Re PLANNING APPLICATION

LU/355/17/HH

16 MADEHURST WAY

We the undersigned have the following
comments on the above

DRAWING BLOCK PLAN DATE: OCTOBER 2017 DRAWN: T. Murray	SCALE 1/500
DRAWING: 17/46/3	REVISION:

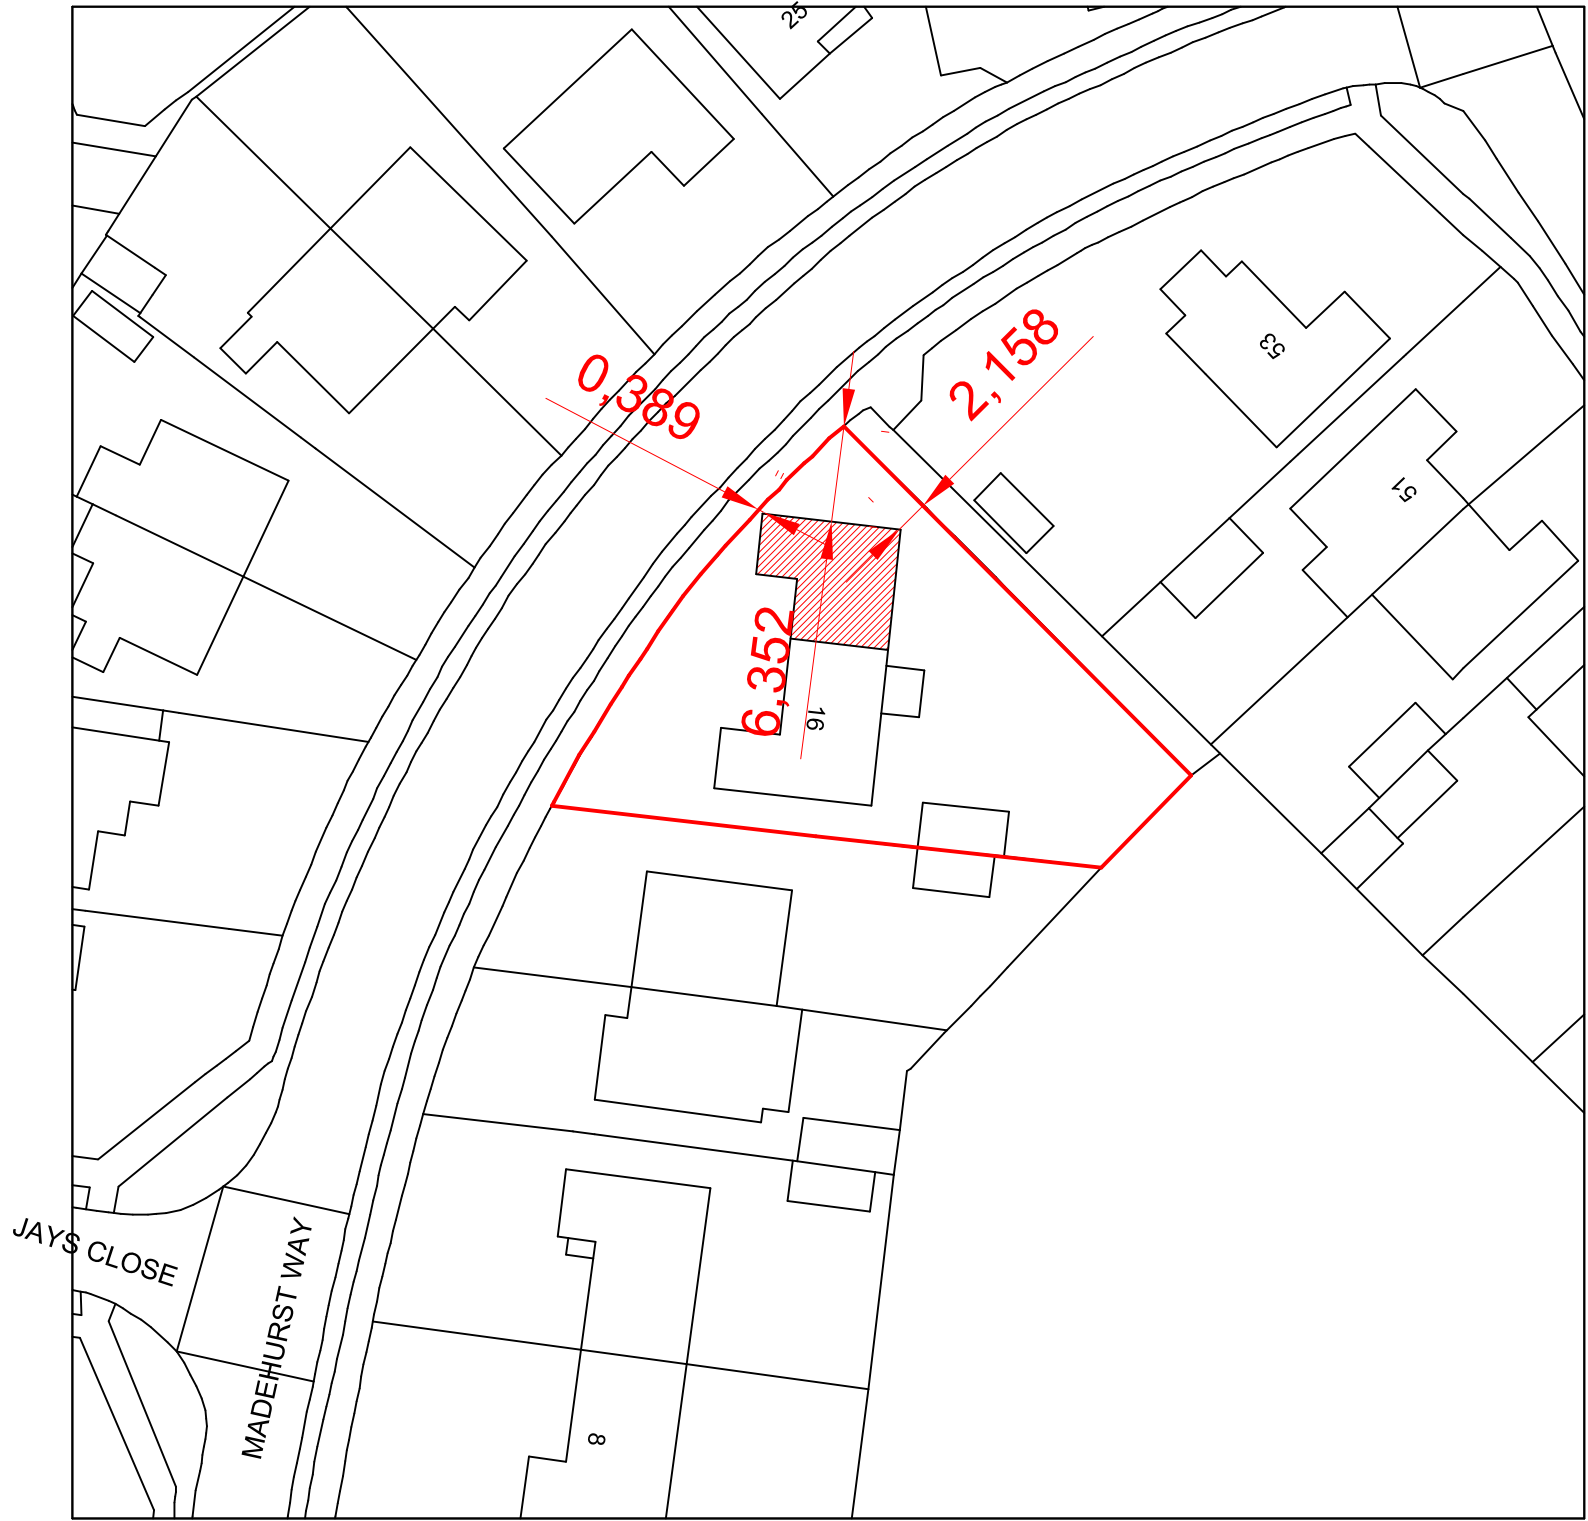
- 1/ Madehurst Way is an open plan road with property set back from the pavement by approx 7-10m or more.

Clearly this annexe is only .389m from the pavement, thereby changing the layout of the estate plan.

DRAWING	SCALE
PLANNING	1/100
DATE: OCTOBER 2017	
DRAWN: T. Murray	
DRAWING: 17/46/2	REVISION:

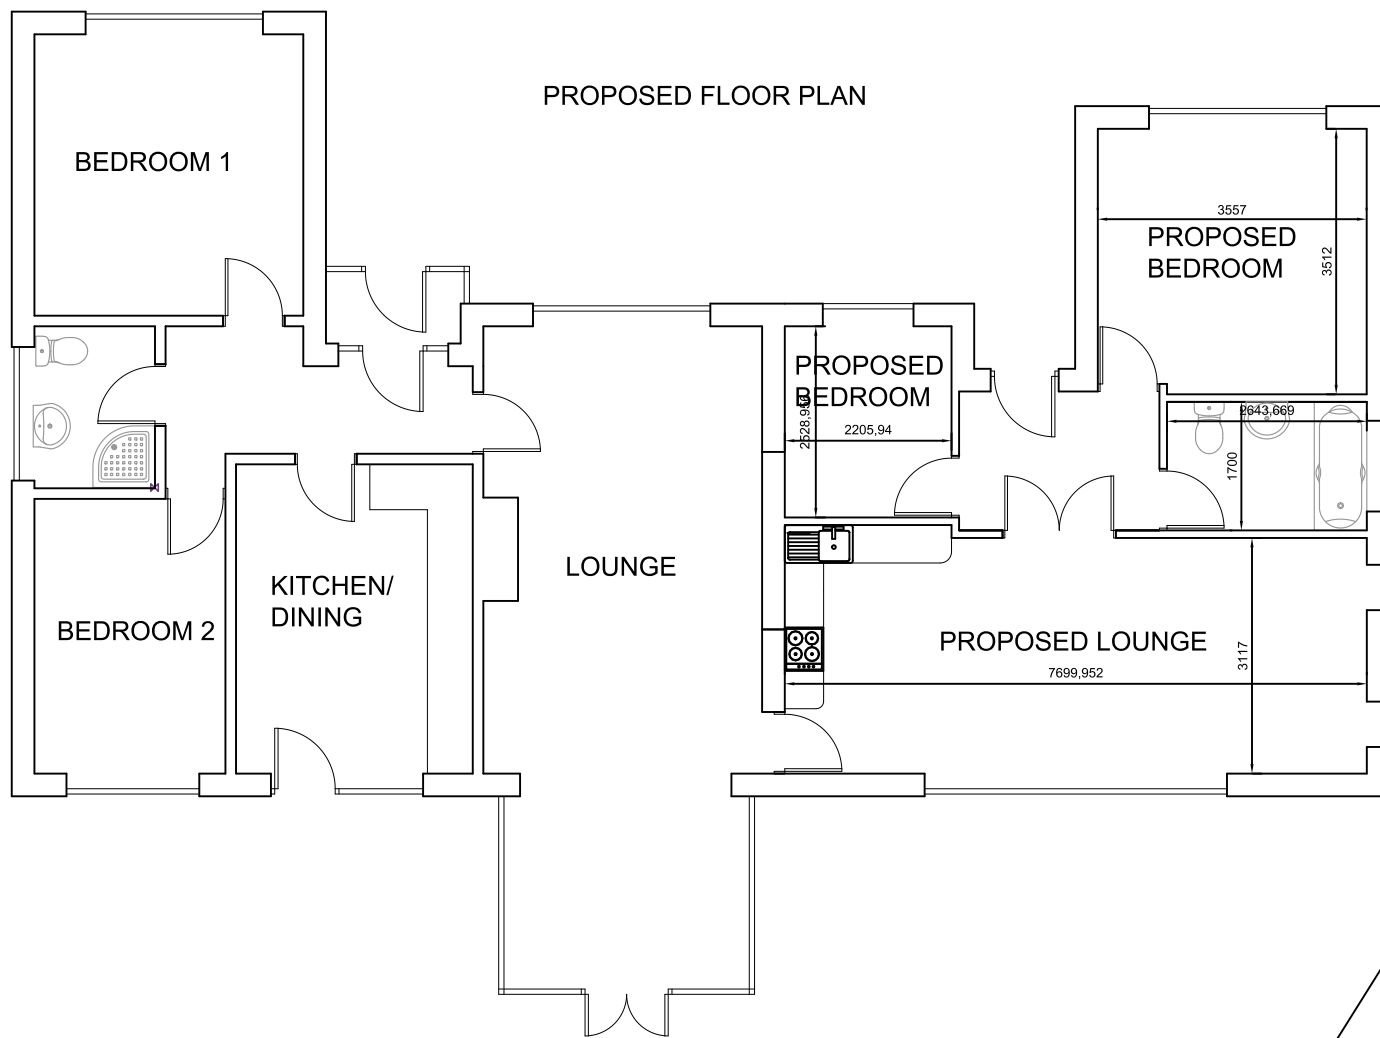
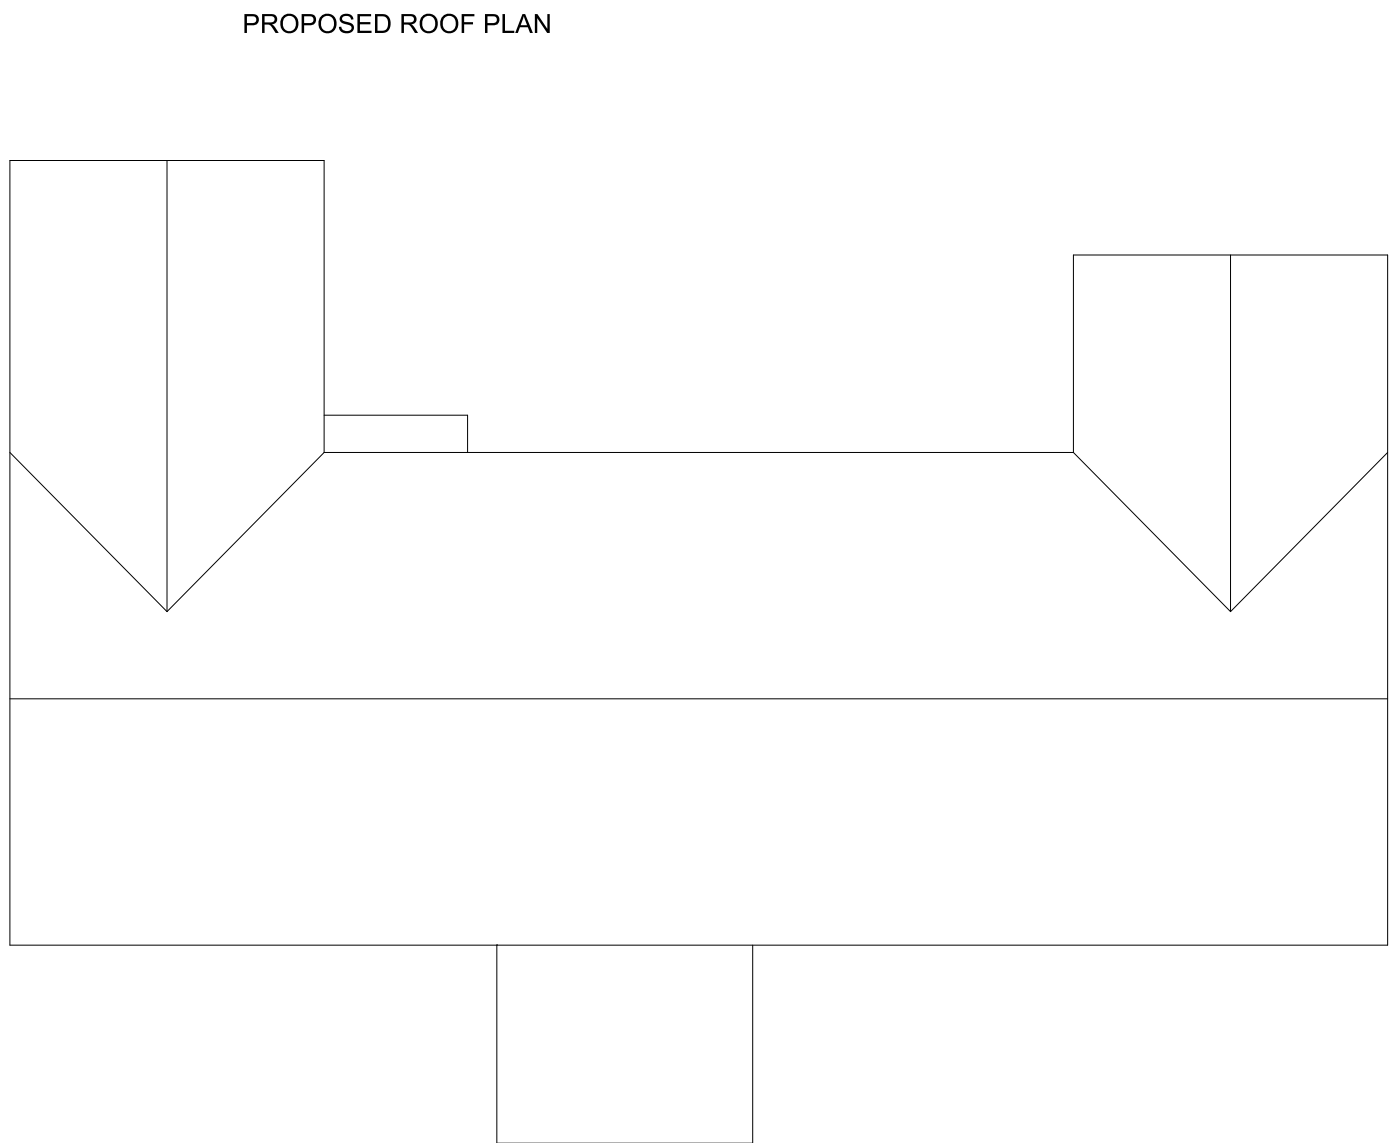
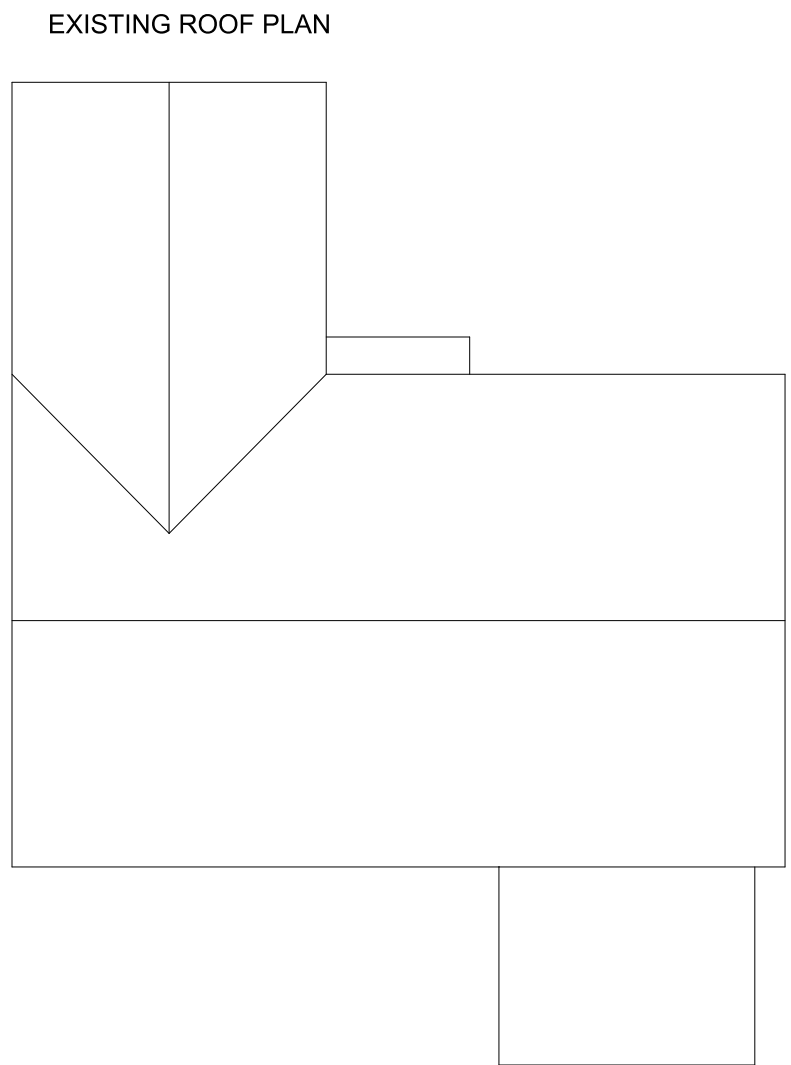
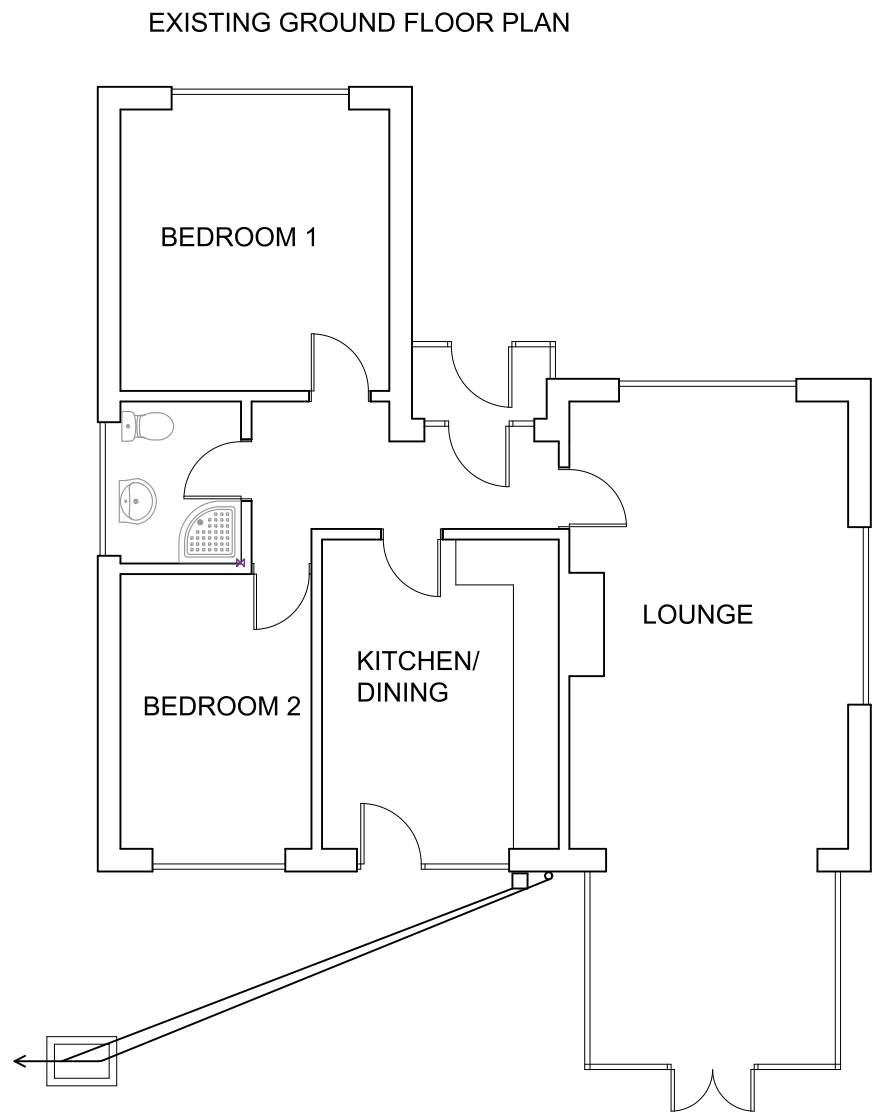
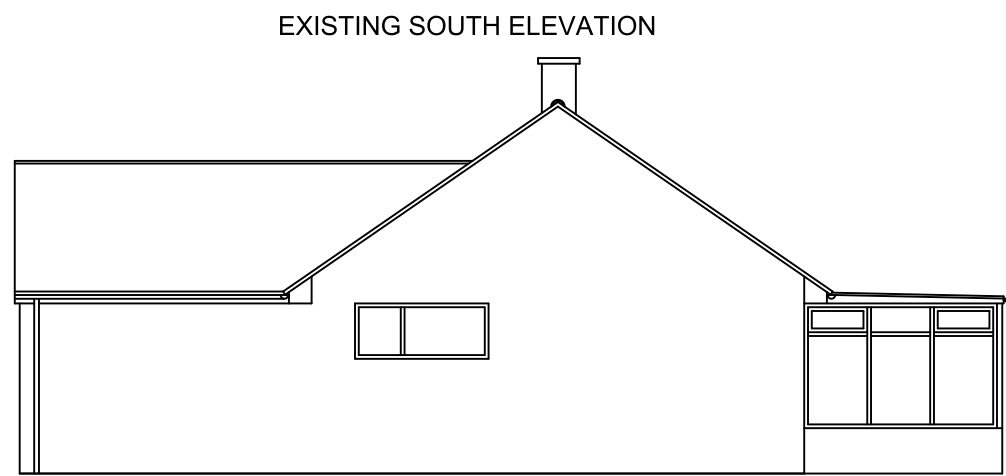
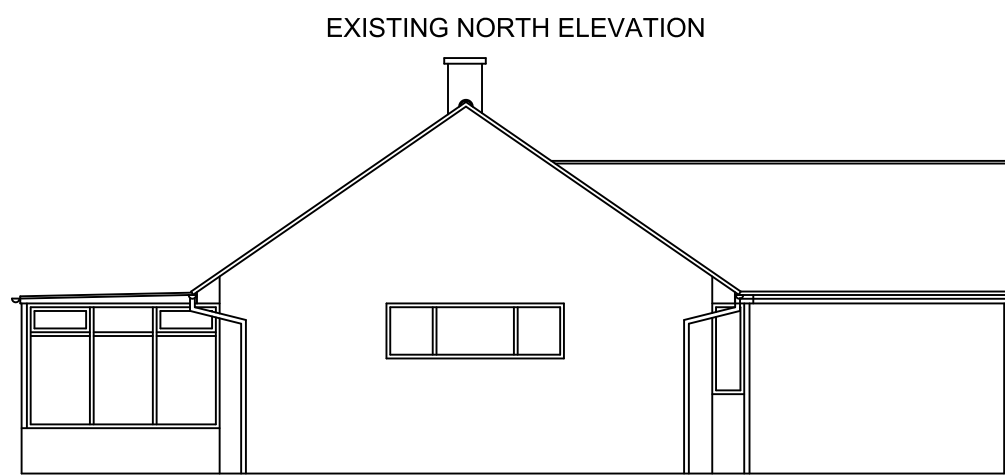
- a/ Our concern is also is this a plan to convert a Detached Bungalow into two units.

When you view the floor plan, if you remove the access between the two lounges you create a separate property

- b/ When you view the proposed west elevation with its own front door, looks very like two units.
